From:
Sent: 02 April 2019 11:19
To: DCAdmin
Subject: FW: Application number 2019/90685

Ref Application no 2019/90685 King James School

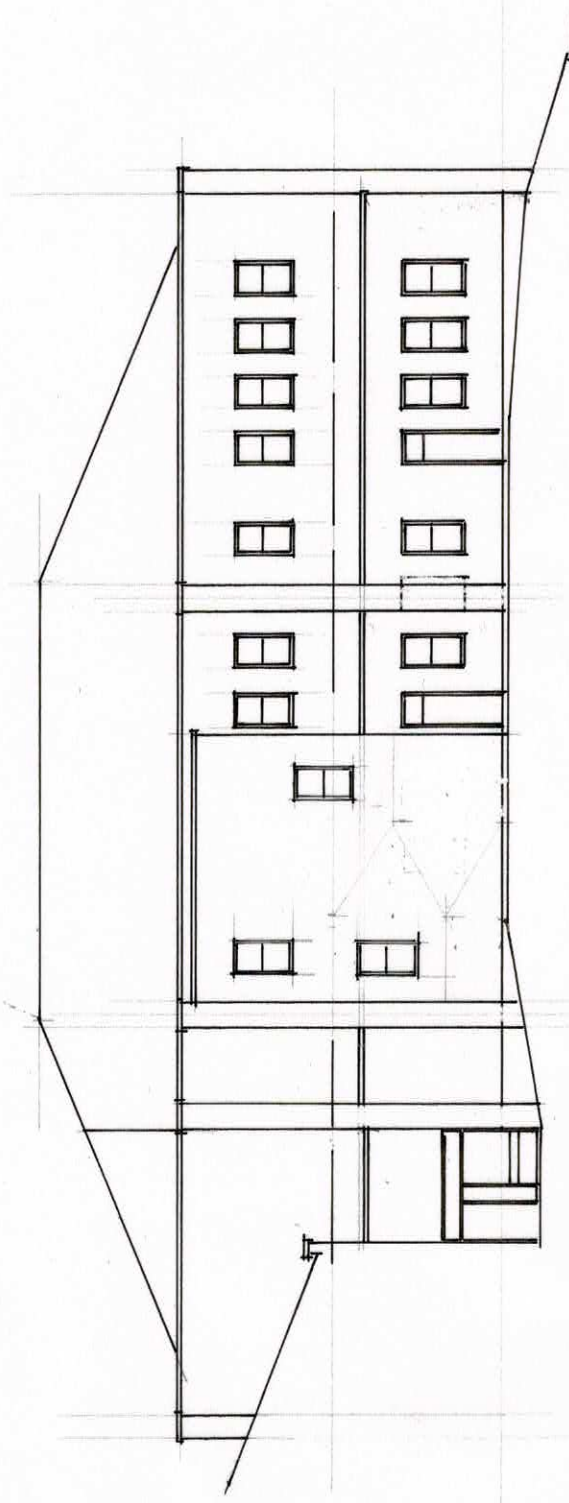
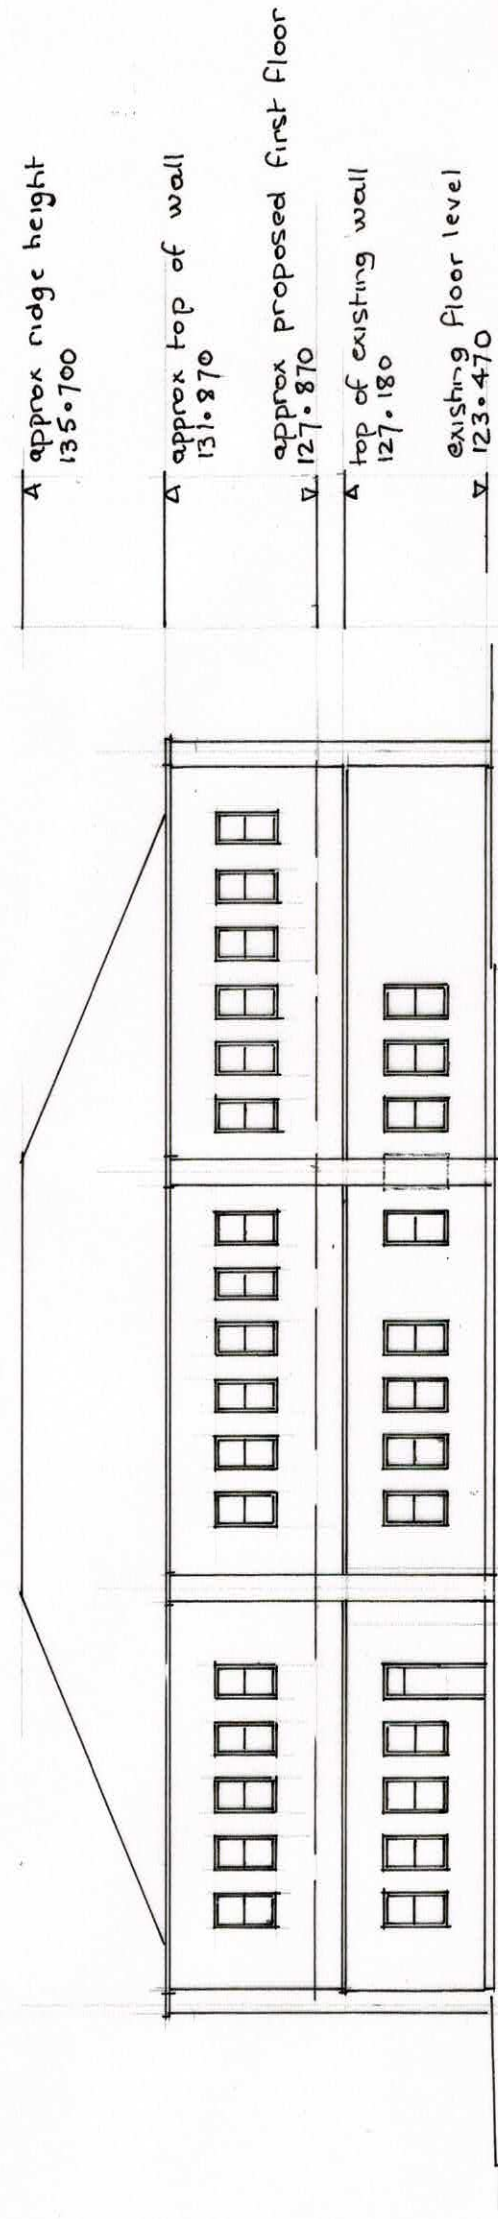
1. Significantly impact on our south/east outlook
2. Overlook our garden & infringe massively on our privacy
3. The north elevation windows on the first floor would look directly onto our property from a greater elevated position
4. Reduce the light levels within our garden
5. Increase the noise levels from the school
6. Create an eyesore of artificial stone, windows & a metal fire escape

The proposed application would increase the height of the current building by 125% - addition of a first floor & a pitched roof.

We believe that some strategic planting of a few mature conifer (or similar evergreen) trees would provide a natural screen, hiding the building from our property & providing a little extra privacy between the buildings.
